From: [REDACTED]
Sent: 08 February 2022 17:37
To: Laura Gibbons; Simon Davis
Cc: Lisa Jackson ([REDACTED])
Subject: Planning Re-Consultation on: Y/184/21/DOC
Attachments: Percolation Tests Details.pdf; Soakaway Tests Details.pdf; 13591-CRH-XX-XX-CA-C-0006-P1_Proposed Infiltration basin calcs.pdf

FM-H-D-101 Rev B N:\Workshop\Projects\London Jobs\GL22428\Drawings\AO Files\GL22428B - DR002 RevB.dwg

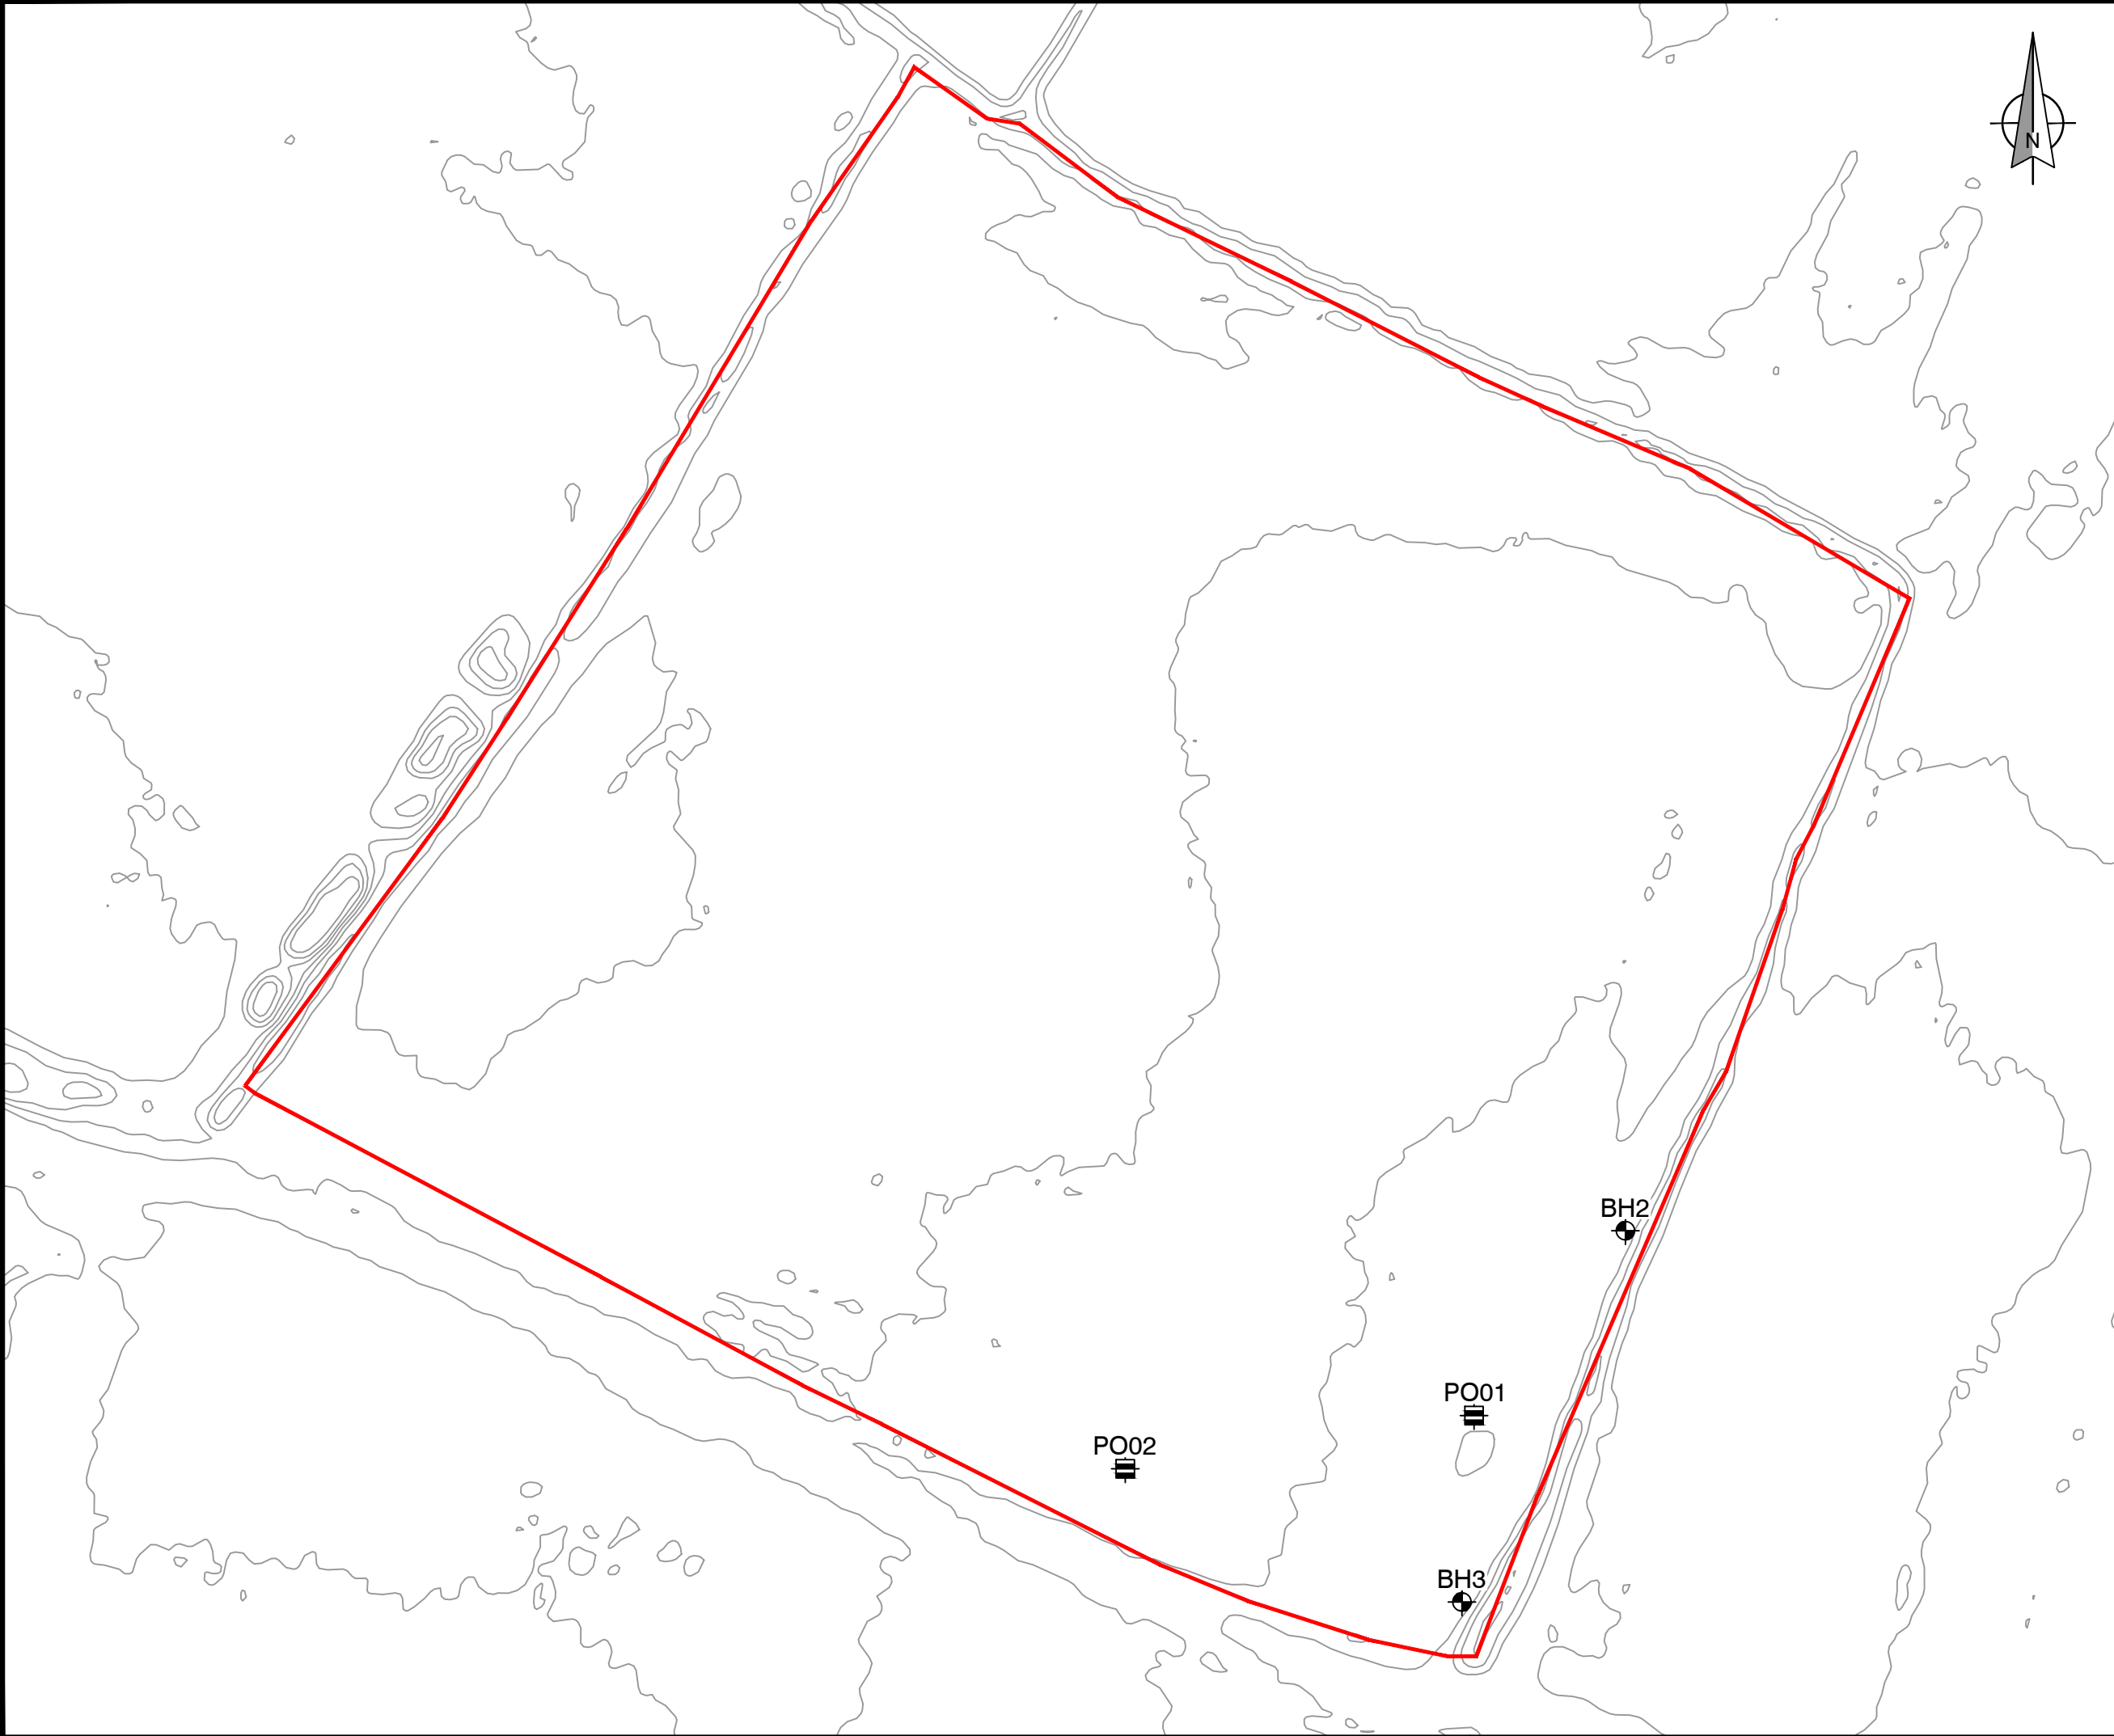
Please find attached layout plan showing location of the boreholes/ percolation test together with details of results -

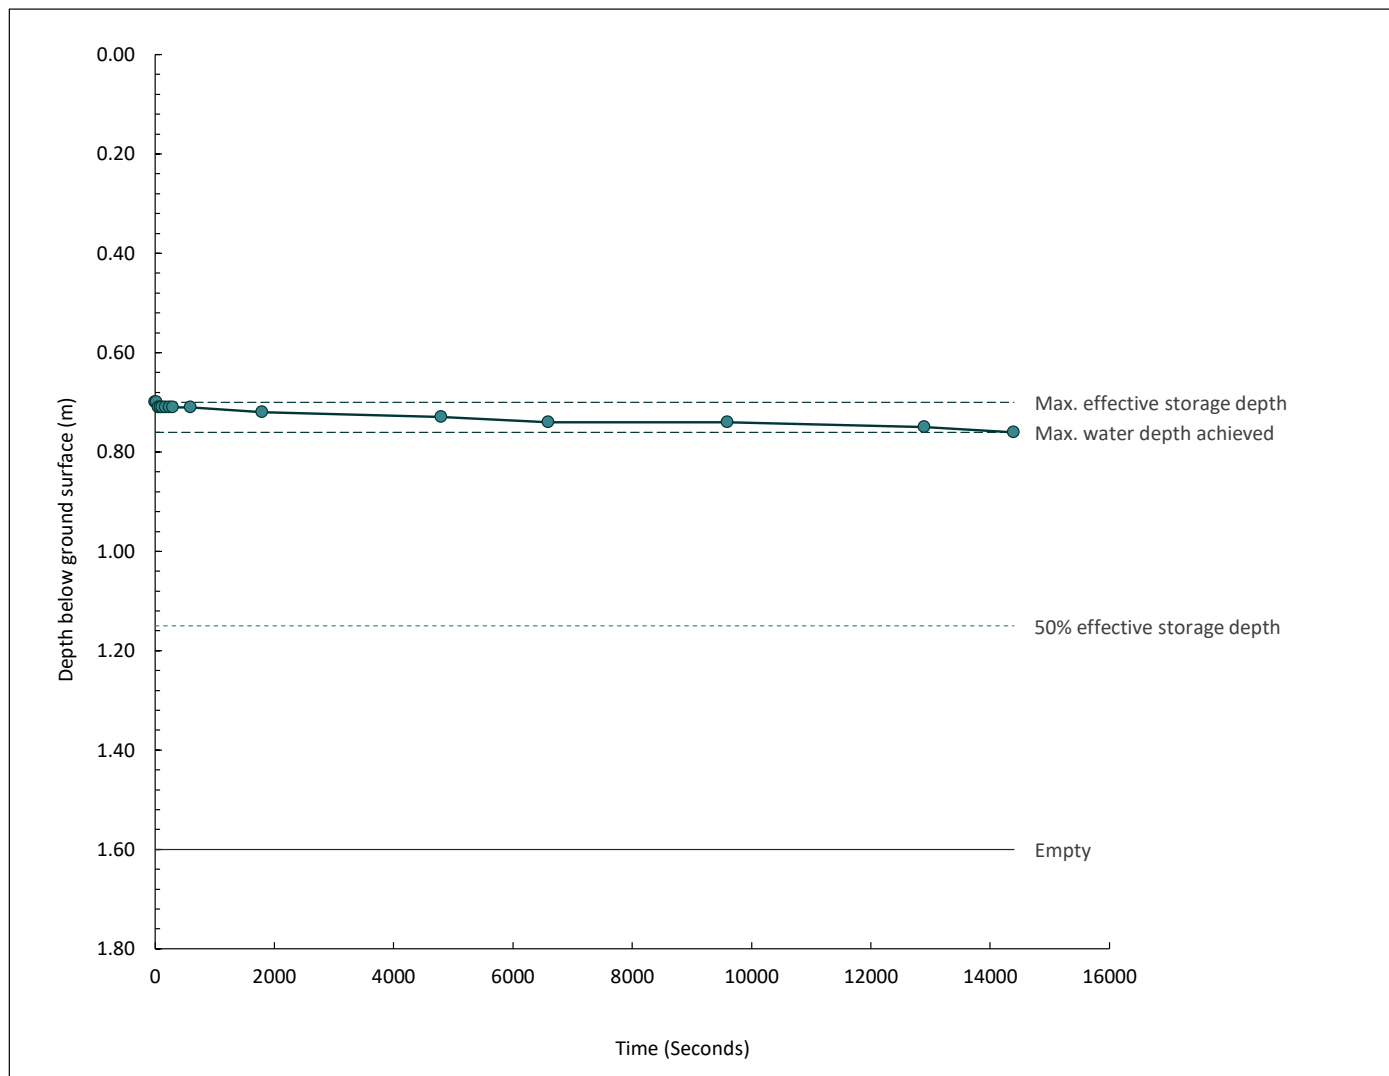
It should be noted that percolation testing (despite having been requested by ADC) is not appropriate for use in the design of infiltration drainage systems. Percolation test should only be used for determination of drainage fields for foul drainage (please refer to Building Regulations Part H for guidance on this). CIRIA SuDS Manual C753, Section 25.3 states that infiltration testing should be undertaken following the BRE method and BRE 365 tests have been undertaken for this site and yielded no infiltration. Please see attached for further details relating to those tests.
